Garage Planning 2020
4 West Drive
Aldwick
Bognor Regis
PO21 4LY

Please ask for: Ms Iqraa Malik
Email: iqraa.malik@terraquest.co.uk
Telephone: 01212341390
Our Ref: AW/302/20/HH
Your Ref:
Date: 3rd November 2020

Application for Planning Permission for Works or Extension to a Dwelling

Development: Construction of a detached garage on the lawn to the front of property
Location: 4 West Drive Aldwick PO21 4LY

Plattegrond / Plan

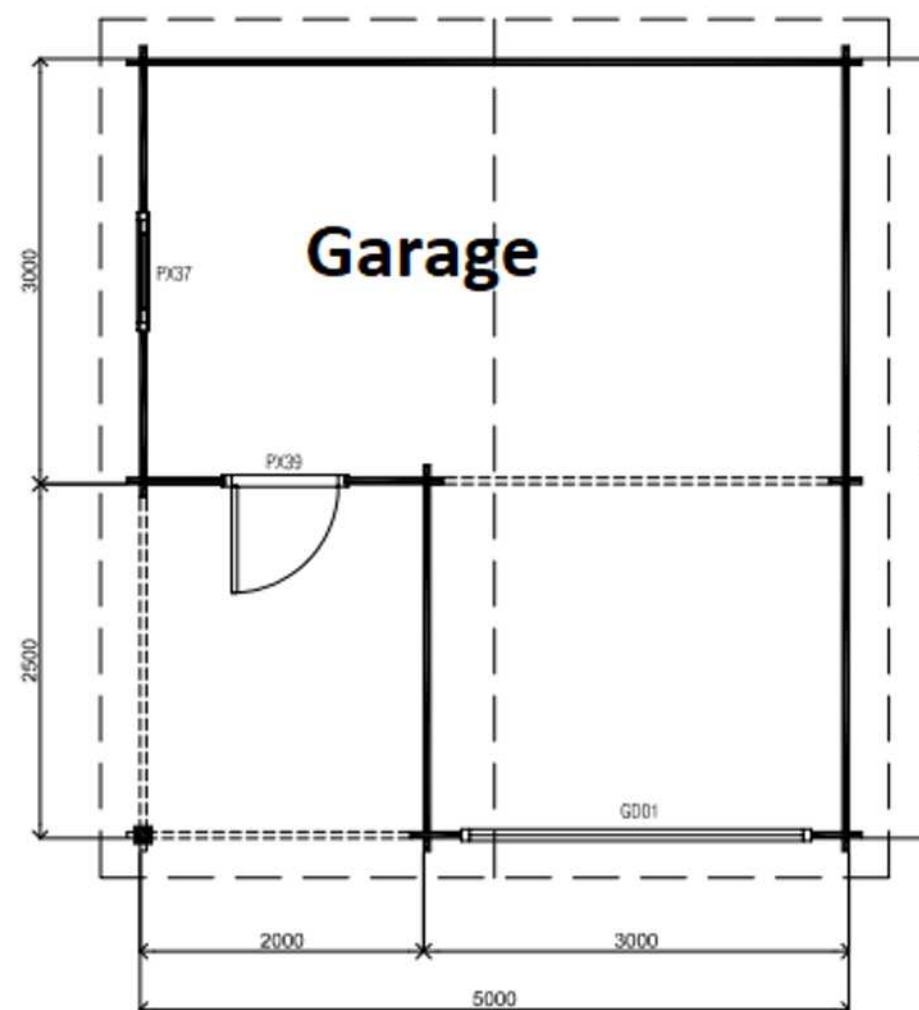
Floor Plan

You are required to have room labels on all floor plans. Please amend.

Pittard_4_West_Drive

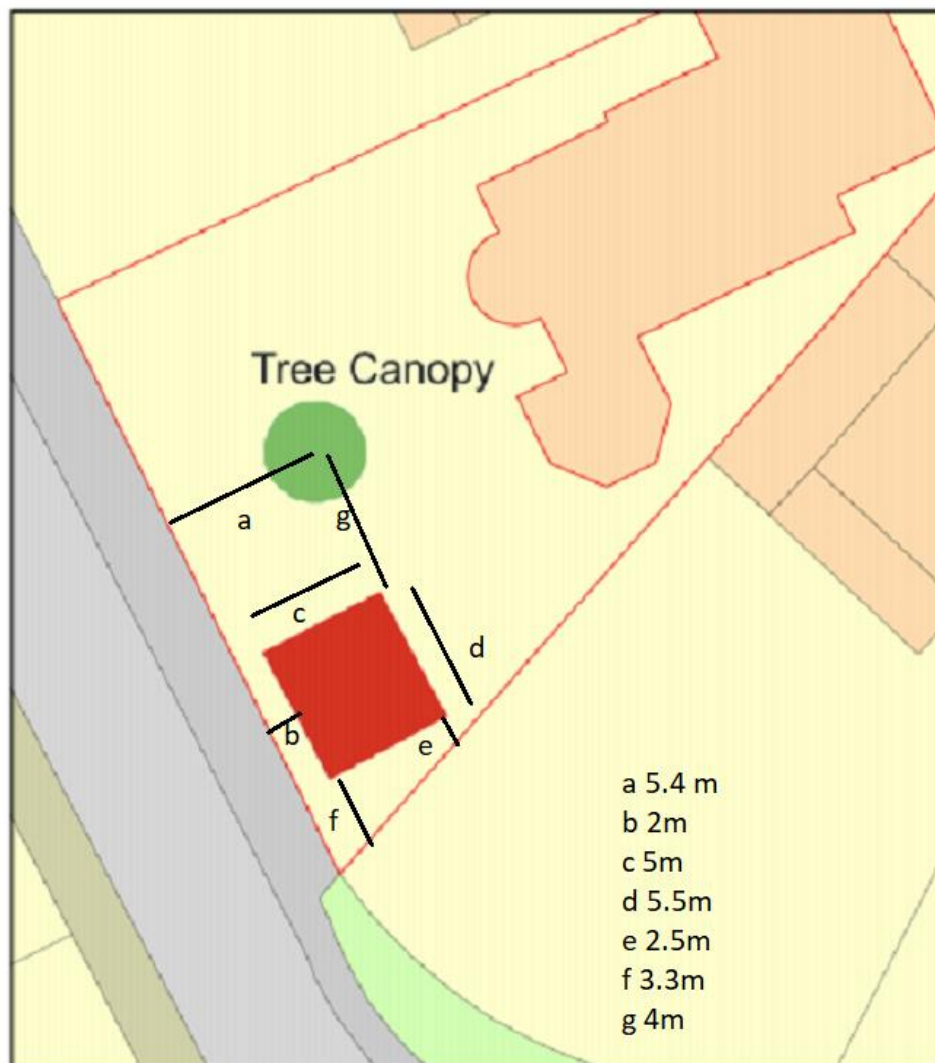
Block Plan

You are required to have dimensions from the proposed extension(s) to all site boundaries. Please amend.
